SITE PLAN
55 GLEN HAVEN WEST
PORTLAND, MAINE
TM 277-I-9
SCALE: 1" = 10" DATE: JUNE 2017

permit application 2017 01226

Bruce Little 35 Glen Haven Rd

Drawing file: 10-10-2017 / 55 Glen Haven West stairs.pdf

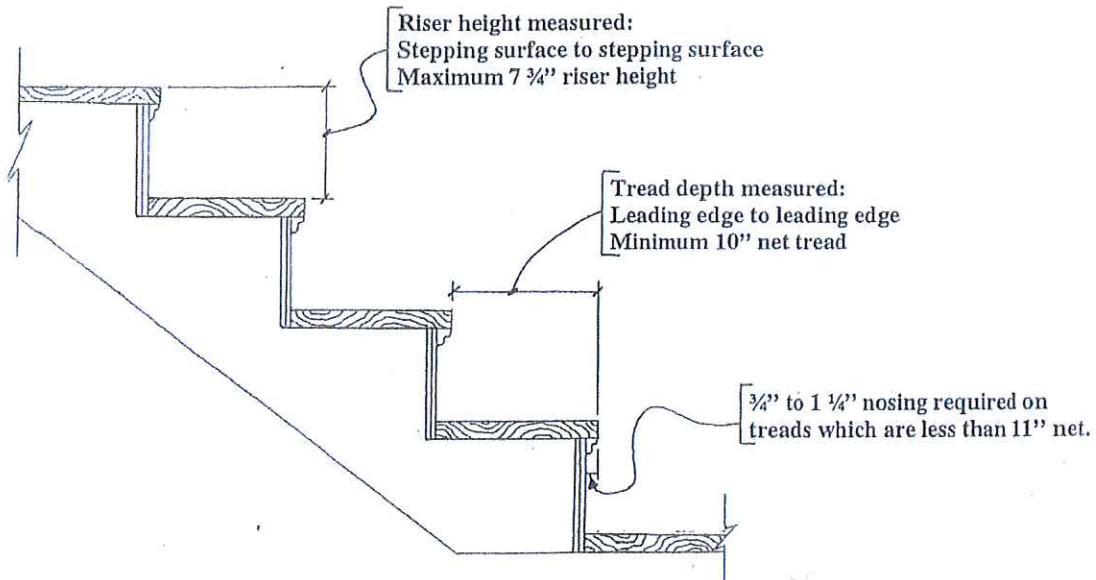
Show dimensions of landings, stair width, tread depths, riser heights, guard height/openings and handrail height/profile as per IRC Sections R311 and R312.

See attached for stair tread depth and height

Handrails will be 34"-36" high with balusters 4" apart

The landing will be 4 ft x 4 ft and the footing will be on cement sauna tubes for frost

TYPICAL WALL SECTION
SCALE 3/8" = 1'-0"

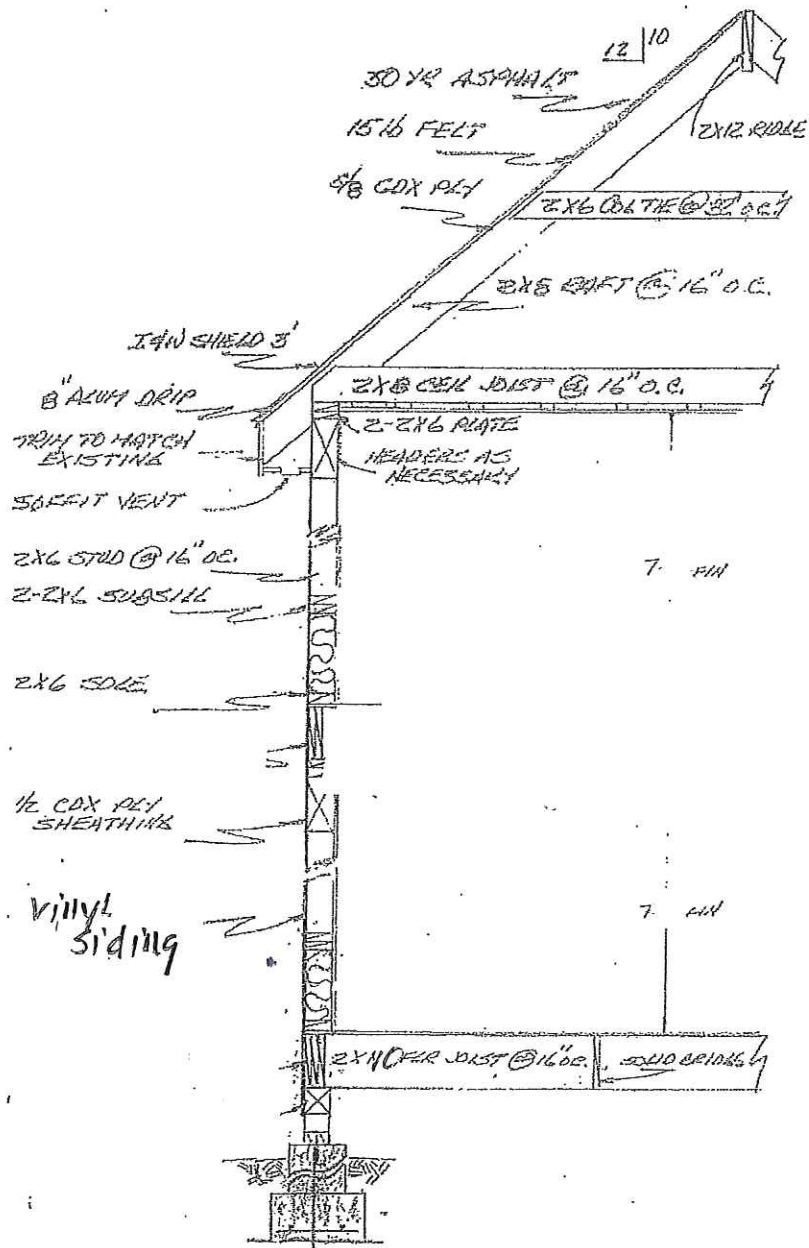
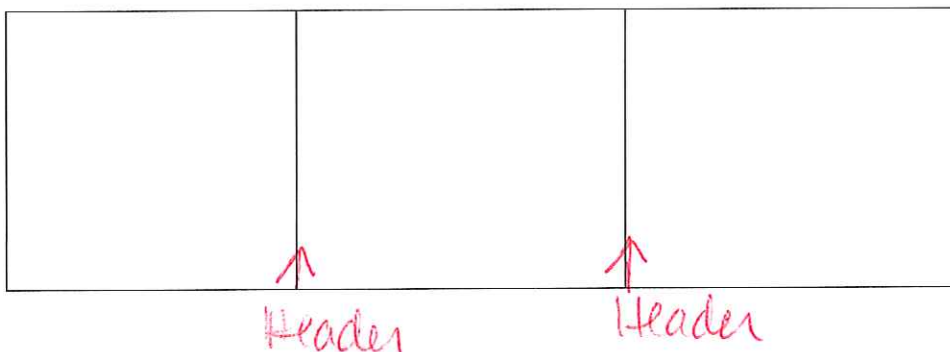
Provide complete cross section of proposed addition showing framing sizes, spacing and connections.

Include entire wall and roof assemblies (siding, roofing, sheathing, insulation, vapor retarder, interior finishes)

Show insulation locations and values as per IECC climate zone 6.

Roof rafters 2x8 and 16" on center with strapping

15" wide R19 Owens Corning insulation on walls

15" wide R30 Owens Corning attic insulation

Polywrap on interior walls with sheetrock

2 x 10 floor joists with a 2x10 carrying beam (three 2x10's together)

Subfloor $\frac{3}{4}$ " tongue and groove

Exterior wrapped in Typar with $\frac{3}{4}$ inch foam insulation and vinyl siding.

Walls 2x6 and 16" on center
